27 May 2021

TfNSW Reference: SYD20/00117/06
DPIE Reference: SSD 10425

RESPONSE TO SUBMISSIONS STAGE 2 DETAILED DESIGN - TALLAWONG STATION PRECINCT SOUTH, 1-15 & 2-22 CONFERTA AVENUE, ROUSE HILL

CONFERTA AVENUE SITE SECTION S

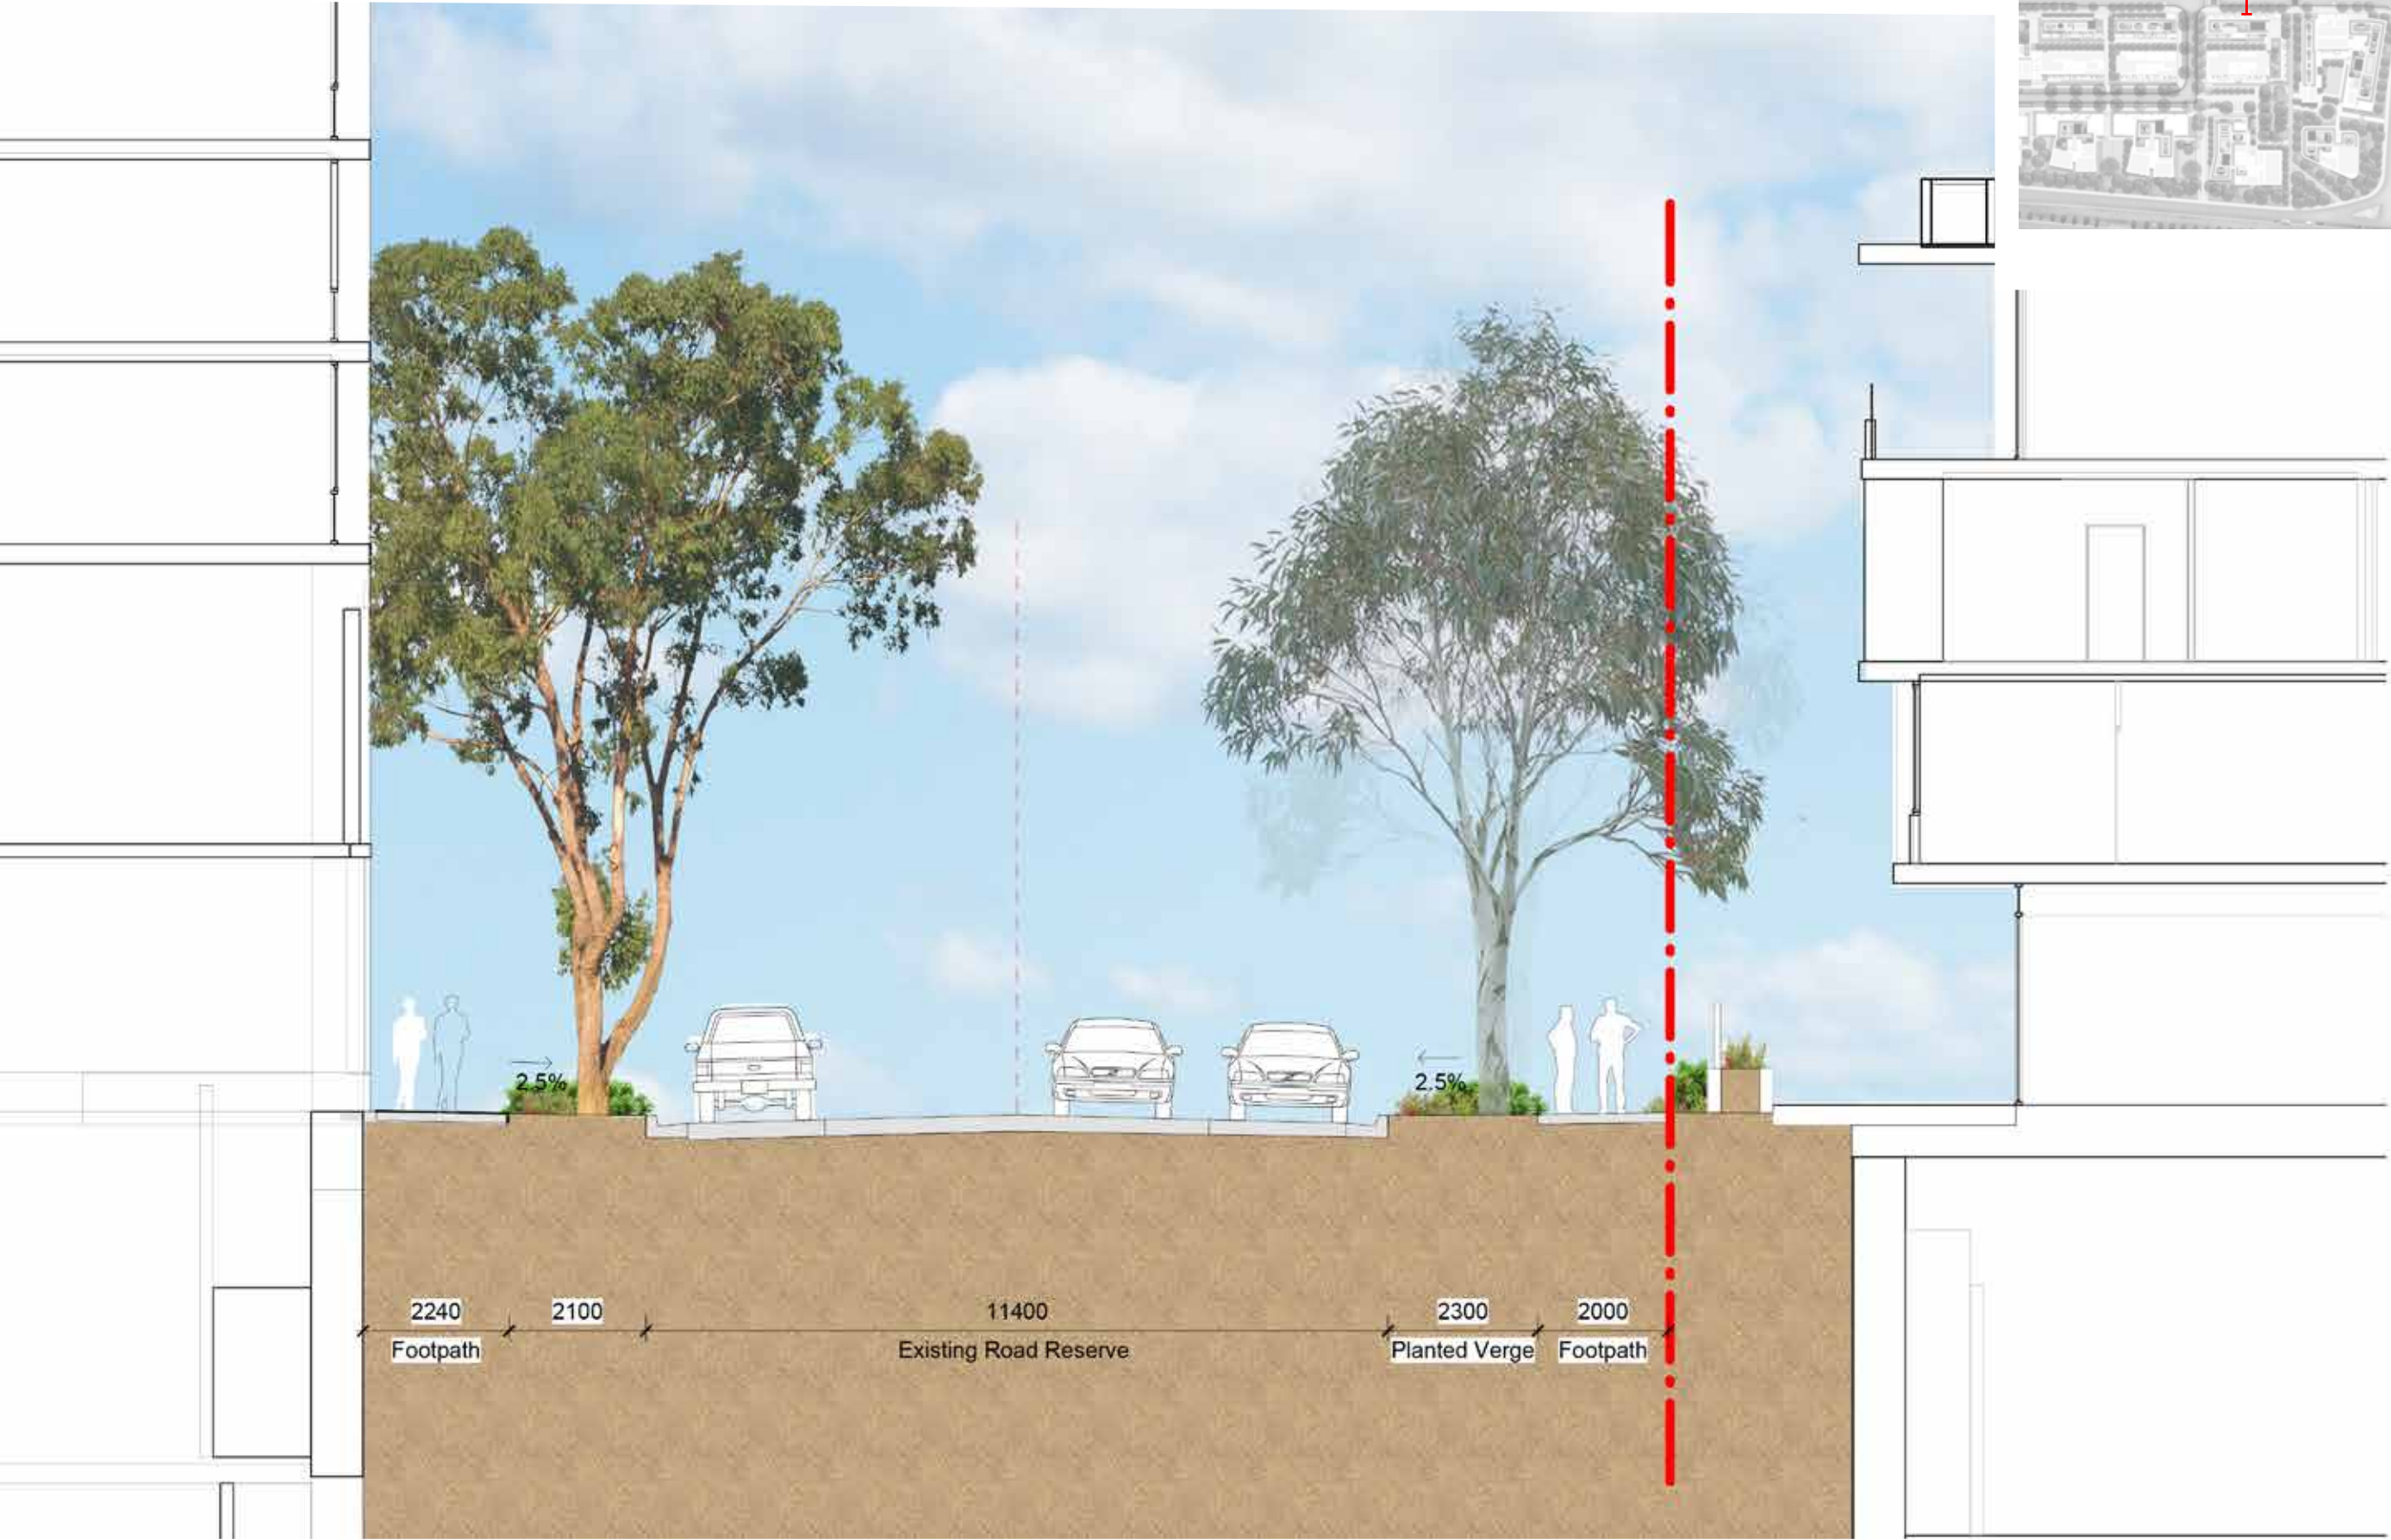
Section 2.5 of the TPIA states that the Conferta Avenue will have a 2.5m wide footpath on the northern side of the road and a 1.9m footpath on the southern side of the road. Cudgegong Road provides a 2.5m wide shared path at the eastern end of Conferta Avenue.

It is noted that the sites propose three north south active transport links through the site with the central link being a shared path.

- The northern footpath on Conferta Avenue for the length of the development site frontage be designated as a shared path with a minimum width of 2.5m (wider if possible); and
- The southern footpath on Conferta Avenue will be widened by 0.5m between tree pits to provide pedestrian passing bays (total footpath width of 2.5m) with the remainder of the footpath being at least 2m wide as per the attached drawings.
